6th March 2019 (by email)

Application No. 6/2019/0217/MAJ

Conversion of Northaw House to form 11 apartments (including refurbishment of existing single caretaker's flat) and underground parking area, the Ballroom Wing to form 2 dwellings, the Stable Block to form 1 dwelling, refurbishment of existing dwelling at Oak Cottage, construction of 2 Gate Lodge dwellings, 3 dwellings within the Walled Garden, 7 dwellings within the Settlement Area, refurbishment of the Walled Garden, refurbishment of access routes and reinstatement of old route, provision of hard and soft landscaping, car parking and supporting infrastructure
At Northaw House Coopers Lane Northaw Potters Bar EN6 4NG

SUBSTRUCTURE PLAN

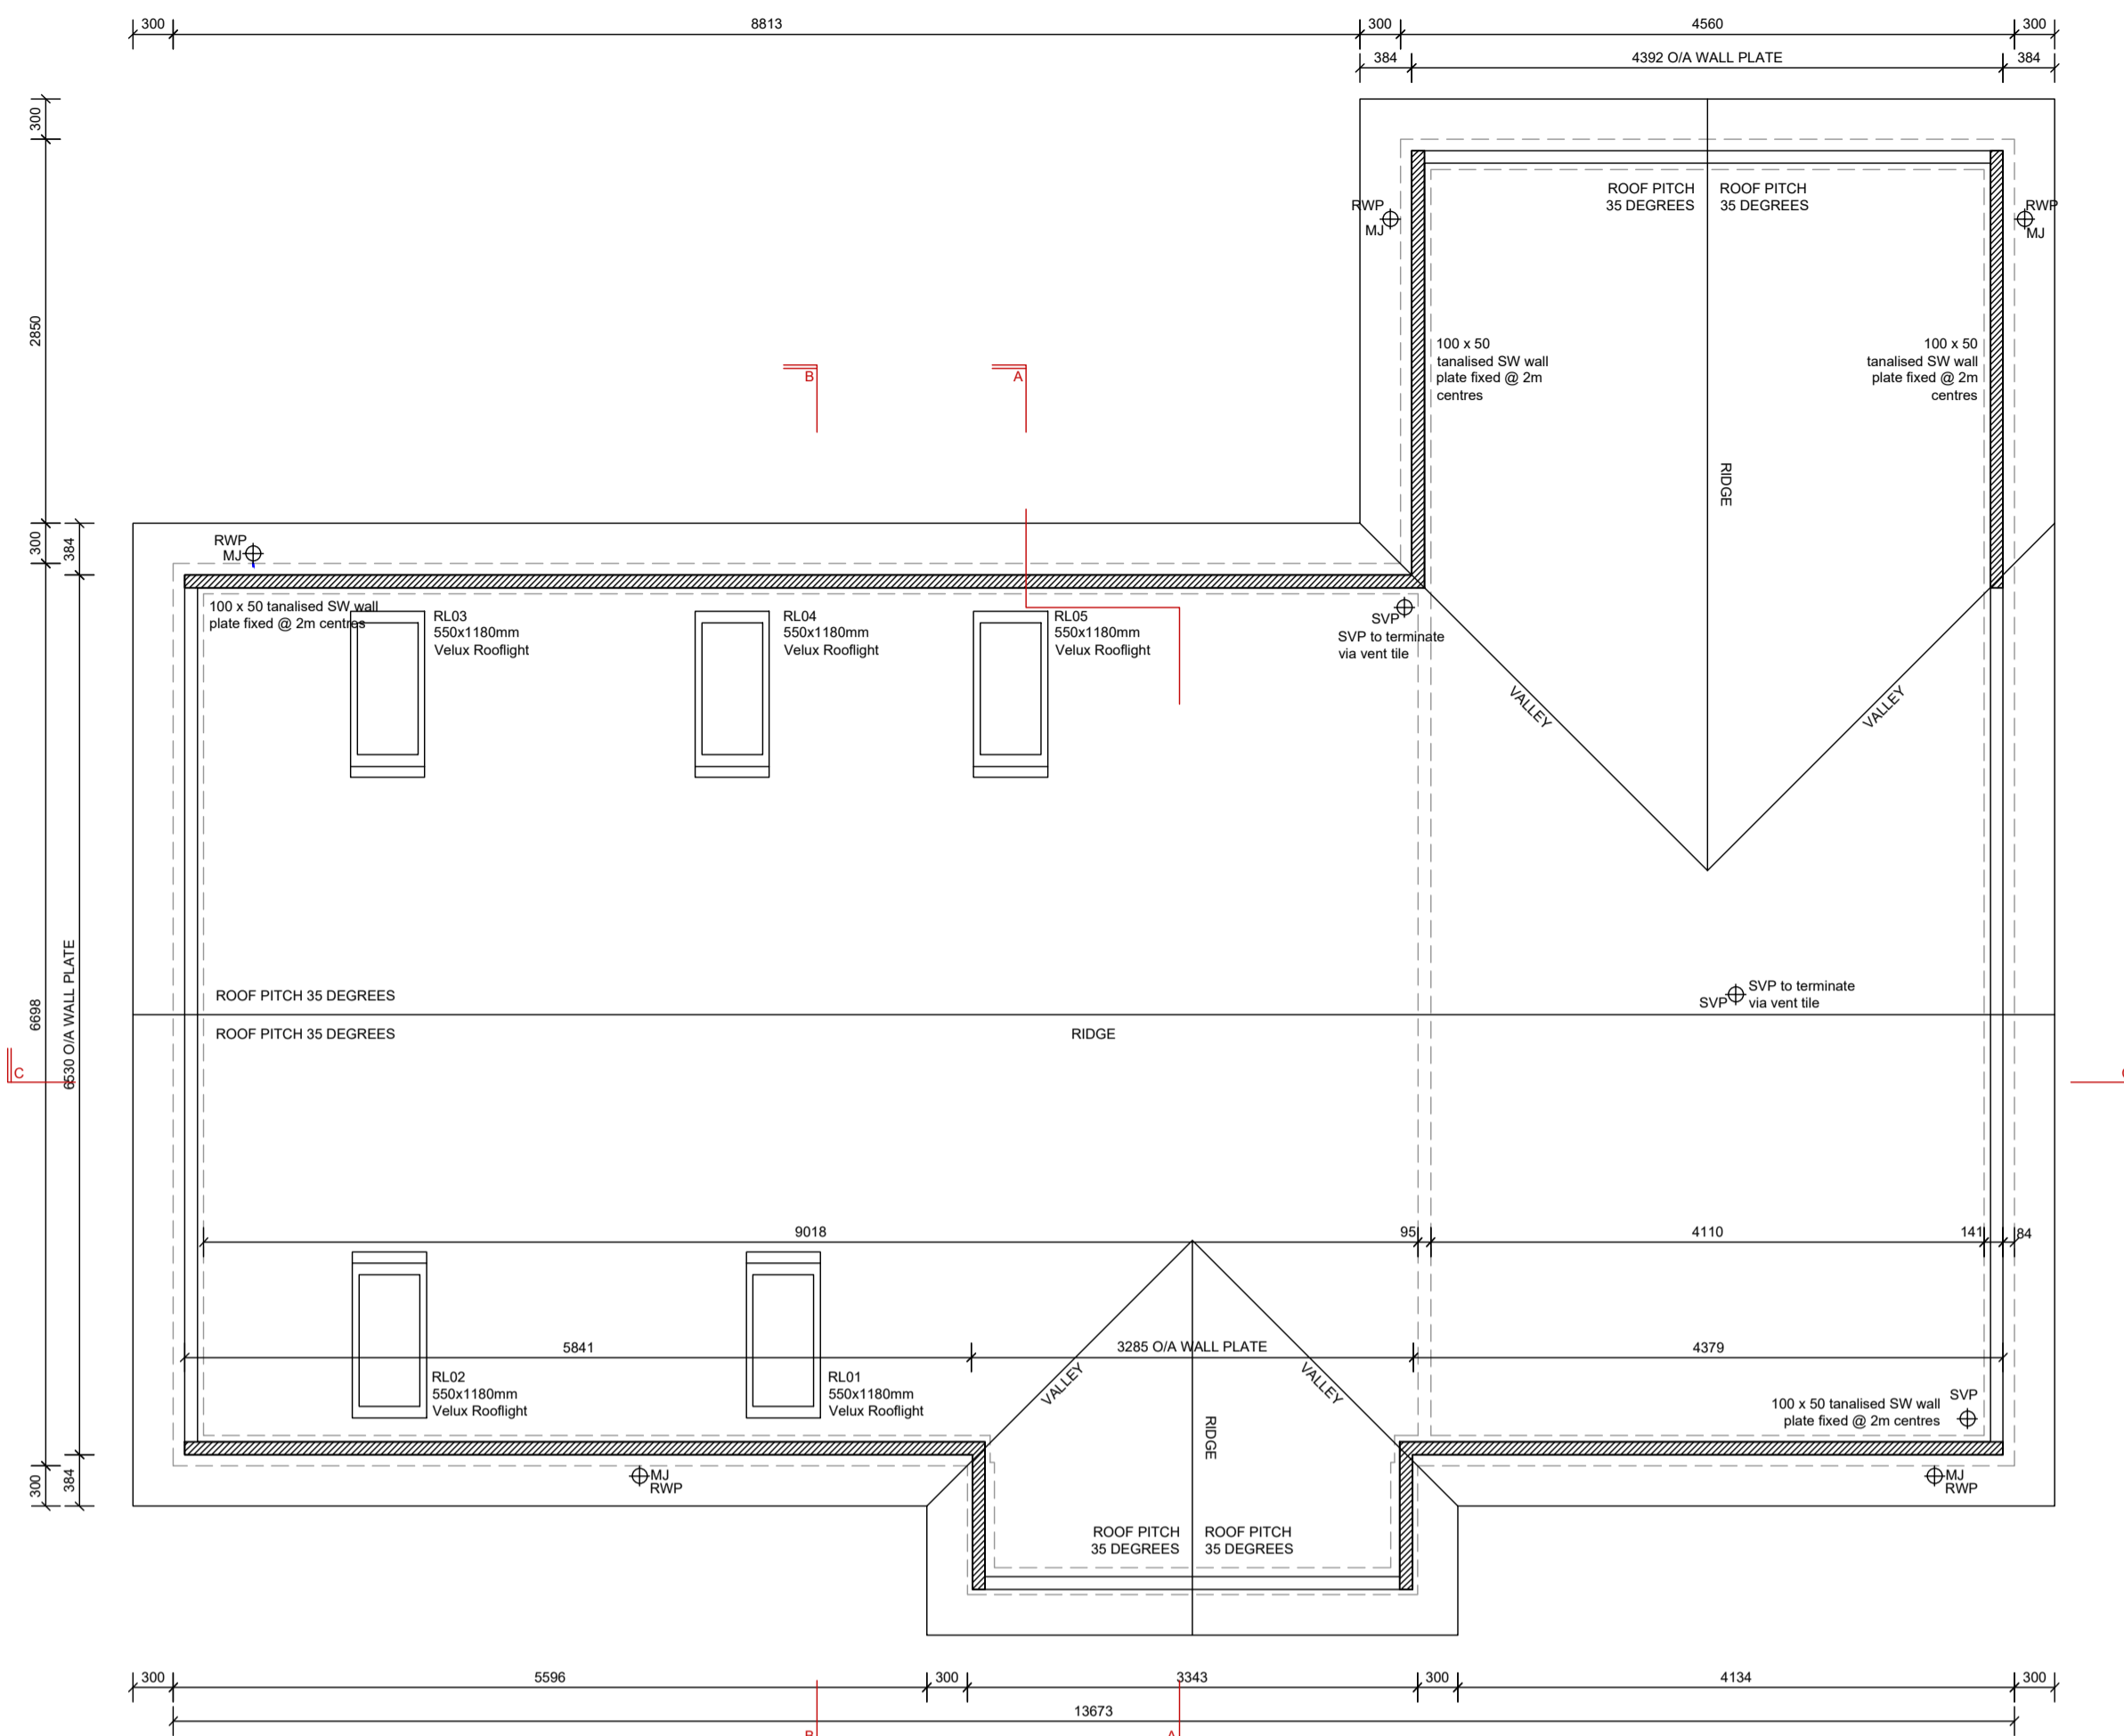
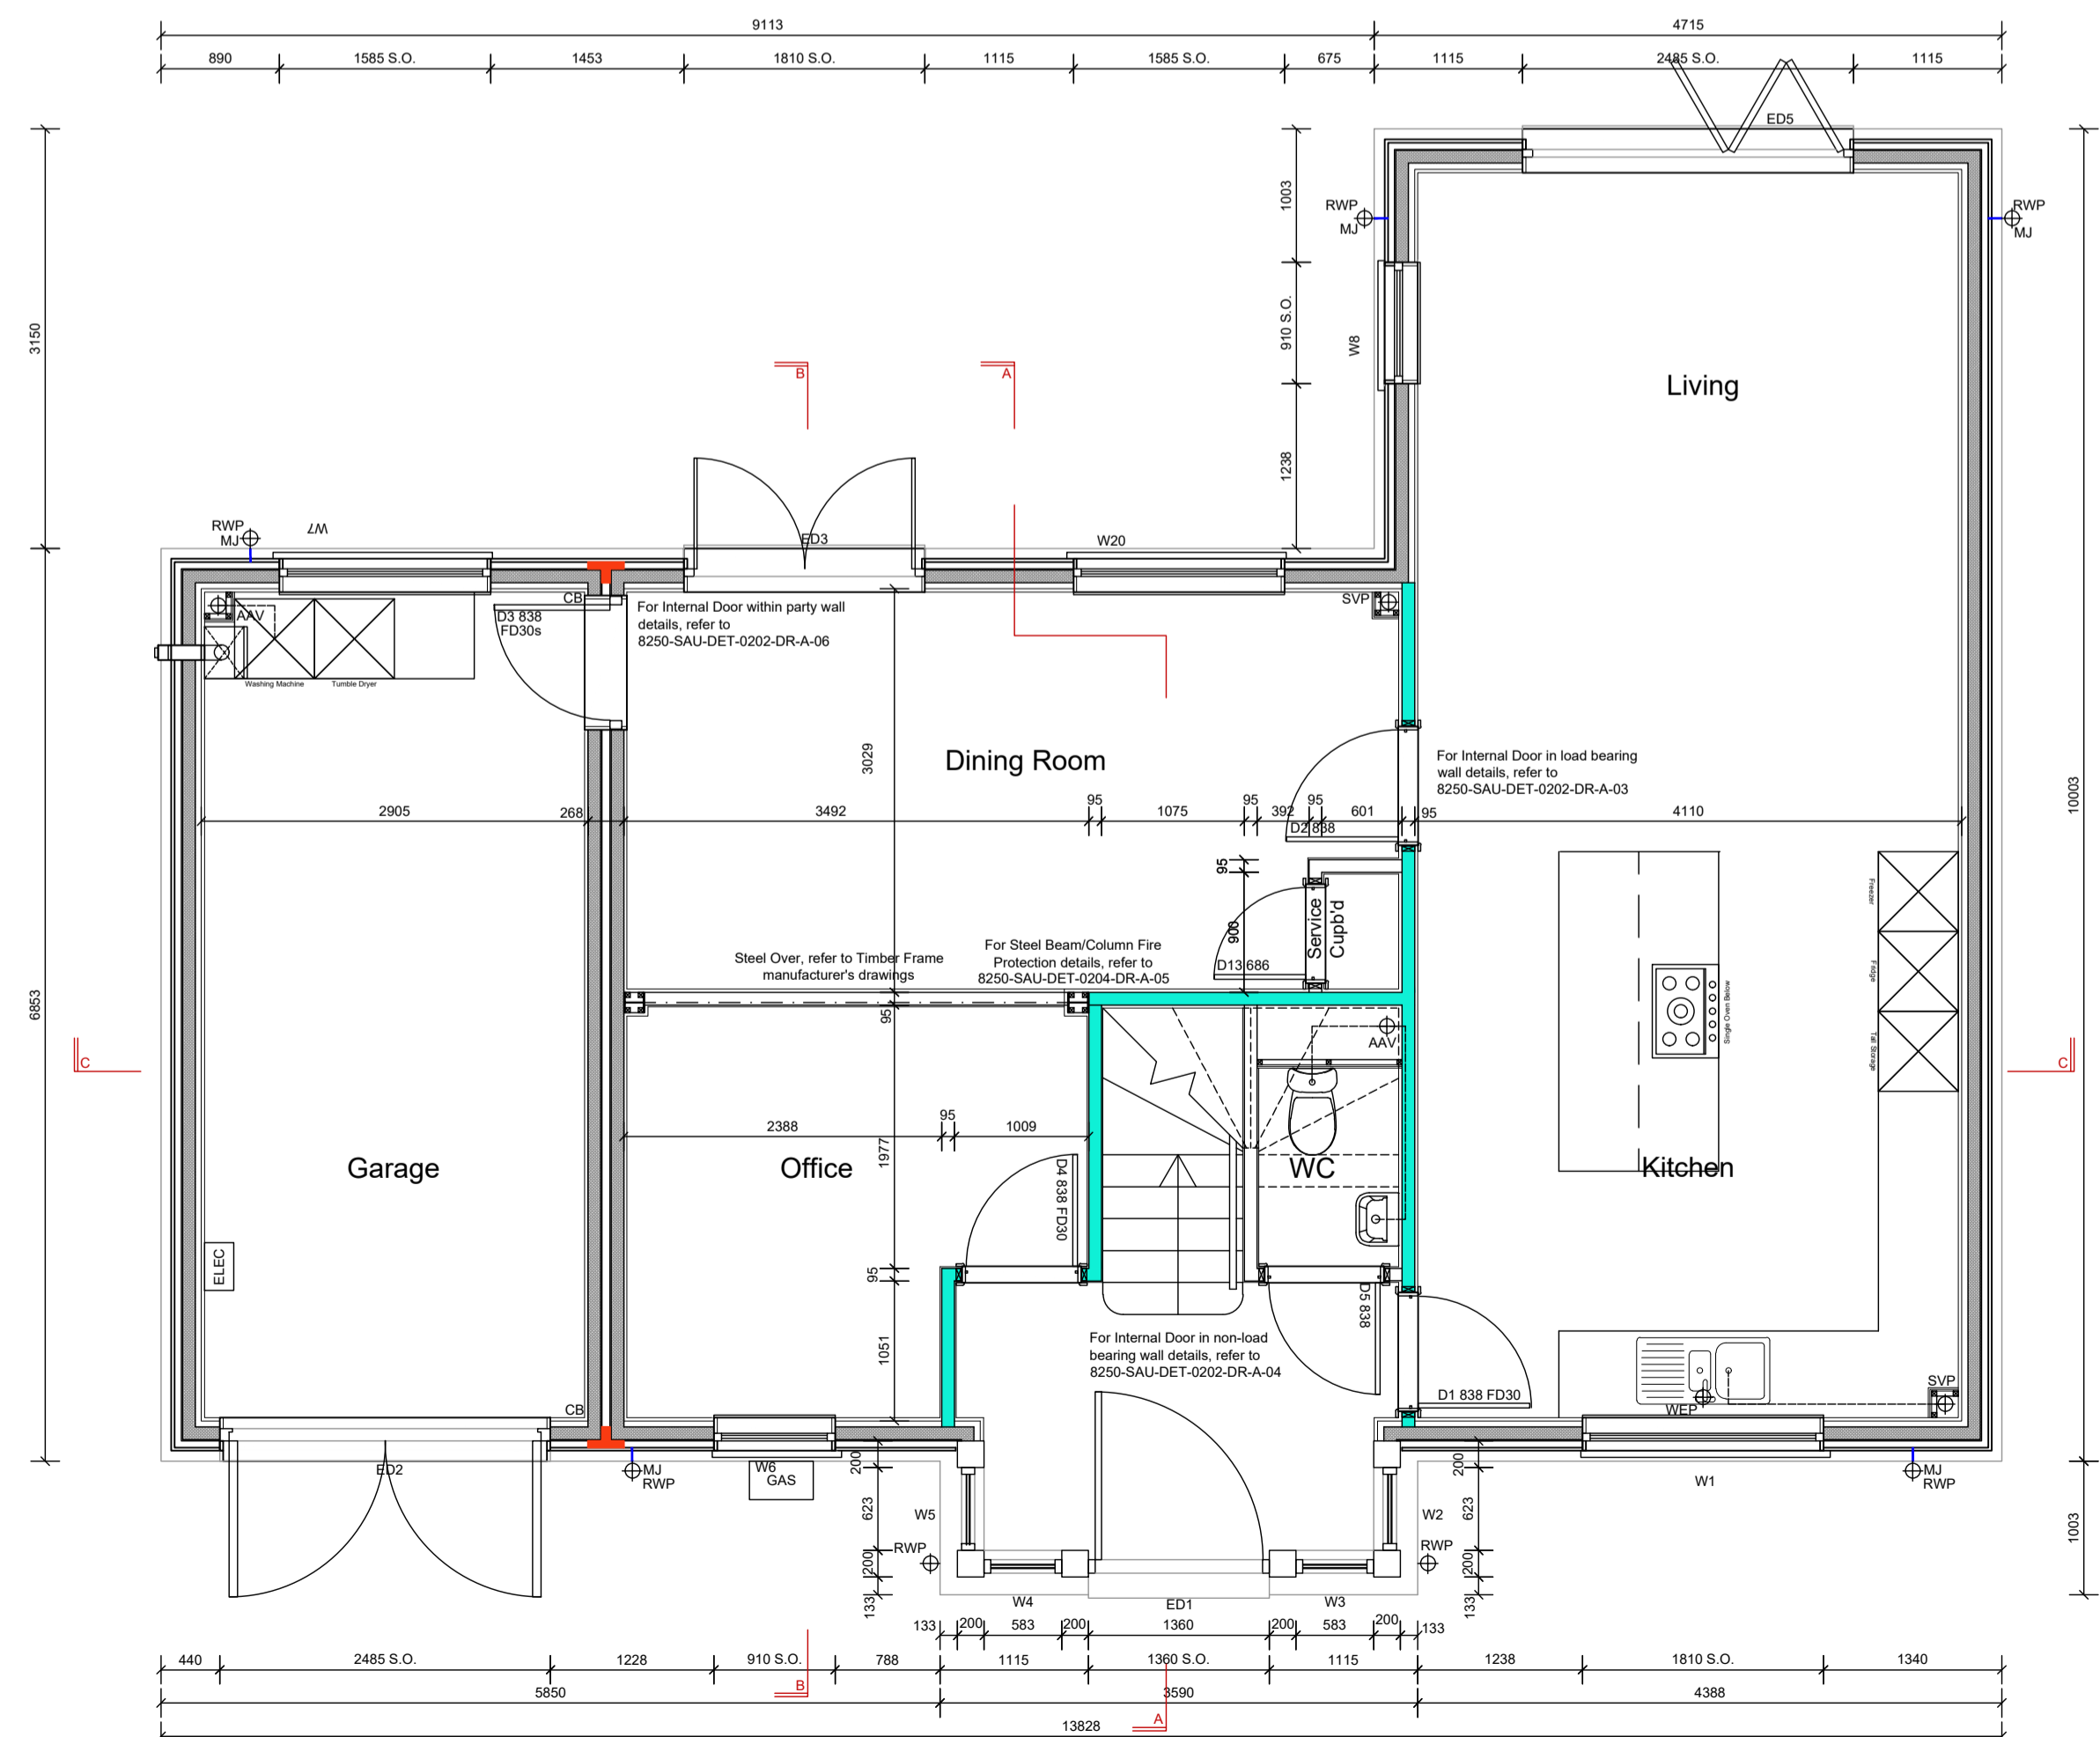
We do not accept the view expressed in para. 84 of the Heritage Statement that the 'settlement units' will effectively appear to be a farm layout providing "a series of high quality agricultural buildings of modern interpretation" which will create "clear visual and physical links to the walled garden." What is proposed is essentially a small cul-de-sac of fairly standard detached and semi-detached housing which has been interposed between the walled garden and the main house. Rather than enhance the links between the heritage assets, it reduces them. Calling the new houses 'The Farm House' and 'The Dairy' etc. does not make them into a farm complex, nor does the layout lend itself to that interpretation.
